**Planning Department  
Transportation Development Services Section**

**Re: GAHP Franciscan Acres Subdivision, 310 Indian School Rd.,  
Building D Only  
Certification Submittal for Certificate of Occupancy –  
Transportation Development**  
Plan dated 01-10-14 (H14-D002)  
Certification dated 2-27-14

SITE DEVELOPMENT PLAN FOR BUILDING PERMIT

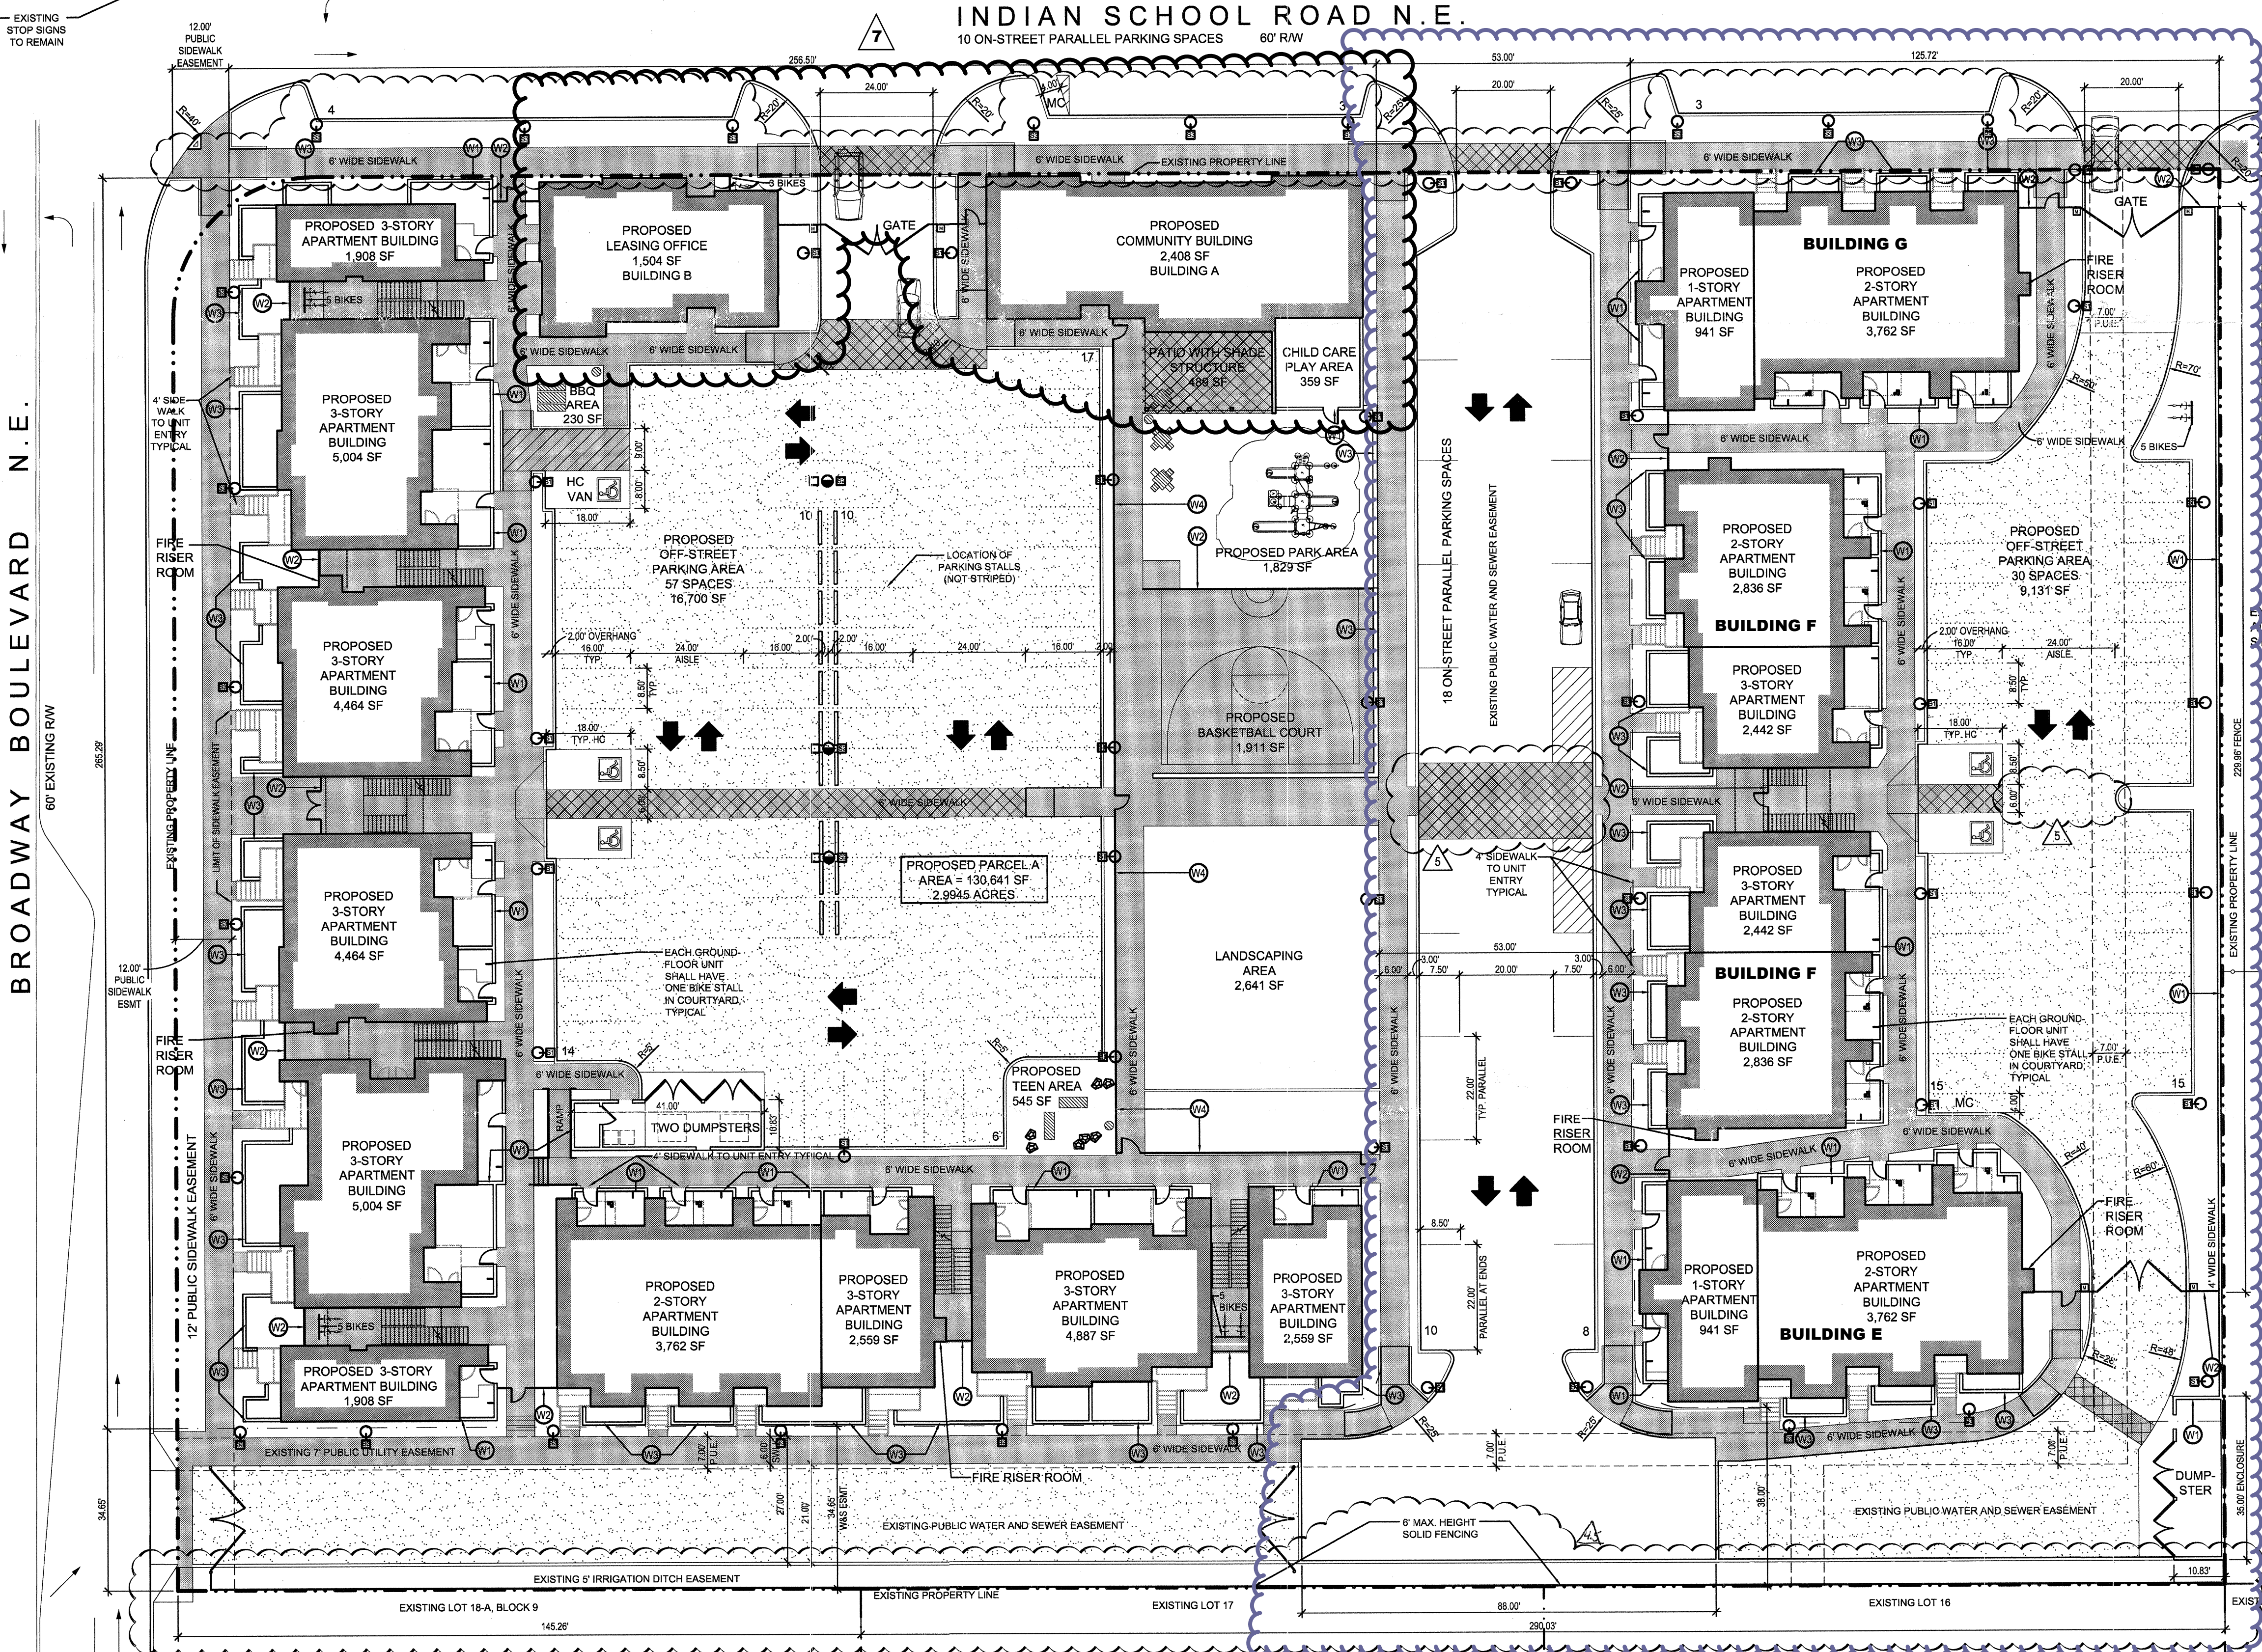
- The Gravel Parking Lot is unstable. Please coordinate with Hydrology and Transportation to plan a solution. Please block all vehicles from parking on the gravel parking lot.
- Reserve two parallel parking spots along the private drive for a temporary HC Accessible parking spot. This condition is temporary and must be removed once the gravel parking lot is stabilized.

The TCL (or DRB Site Plan) submitted for Final C.O. needs to be the exact copy of the approved TCL in the plan set approved for building permit. This will be the latest edition, which may have redlined comments, initialed and dated by the designer-of-record.
